From: Belinda Tan [REDACTED]
Sent: 06 December 2018 07:21
To: Nicola Moore
Subject: Re: FW: AW/281/18/T
Attachments: tree 2.pdf; tree application dec18.pdf

Subject: AW/281/18/T

From: Belinda Tan [REDACTED]
Sent: 26 November 2018 12:30
To: Planning.Responses
Subject: Re: Further Information Required on Your Ref: N/A Our Ref: AW/281/18/T

Chestnut
that needs
thinning.

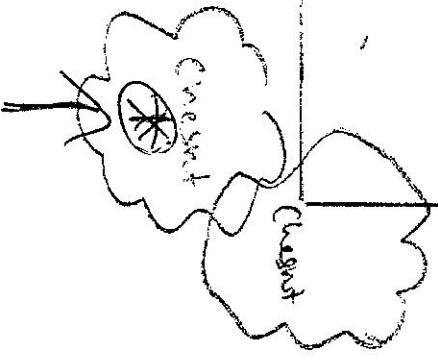
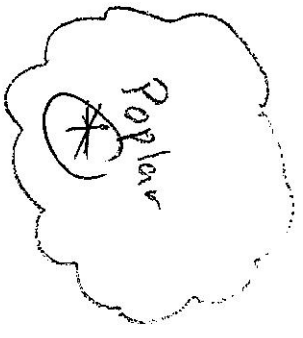
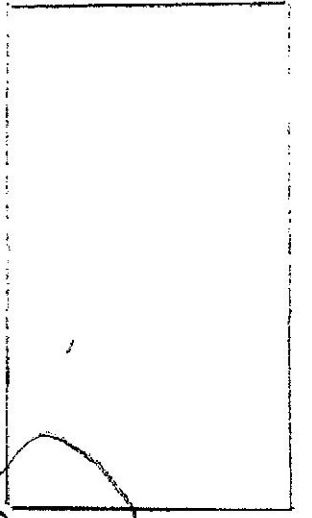
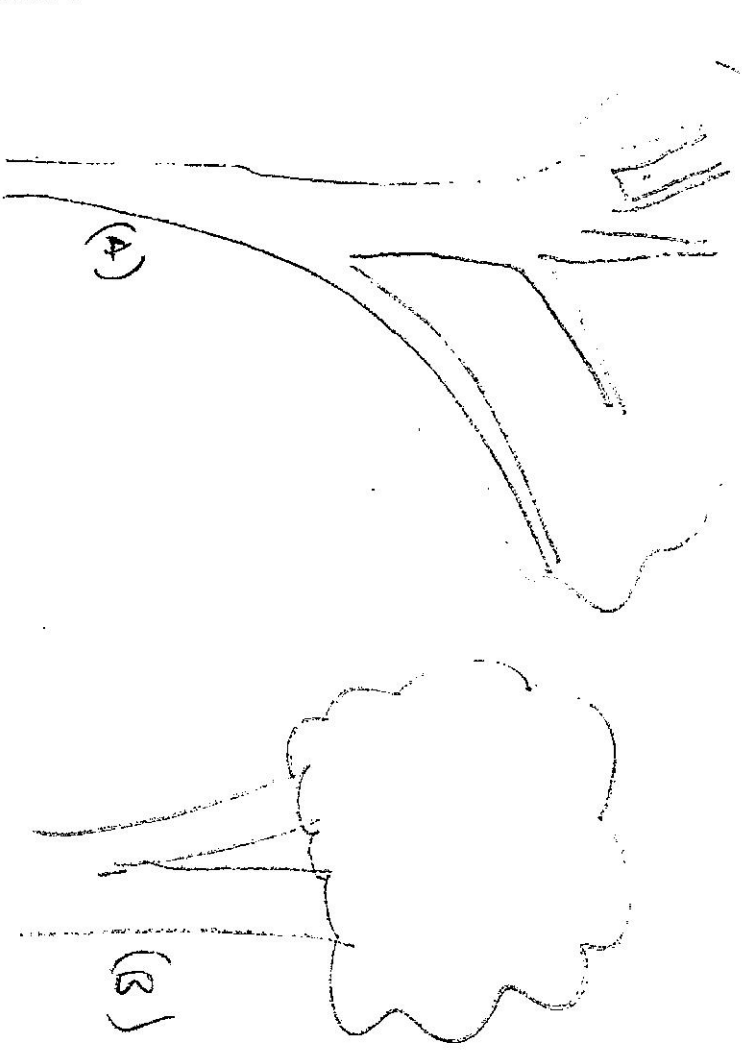
I have attached a copy of the application so that you can complete Section 9 and return it to me. I have also attached a copy of the sketch plan you sent, please could you clearly mark which of the 2 Horse Chesnut trees requires thinning. With regards to the arboriculture advice you are now required to provide, when you have received the advice please forward a copy to me.

- As you have ticked Yes in Section 8, you are required to provide written arboriculture advice or other diagnostic information from an appropriate expert.
- Please complete Section 9 of the application form.
- Please clearly highlight on your sketch plan which Horse Chesnut tree requires thinning.

Thank you for your email, apologies for not replying sooner - not sure how I missed your previous email. Please find as attached sketch indicating which tree needs thinning.
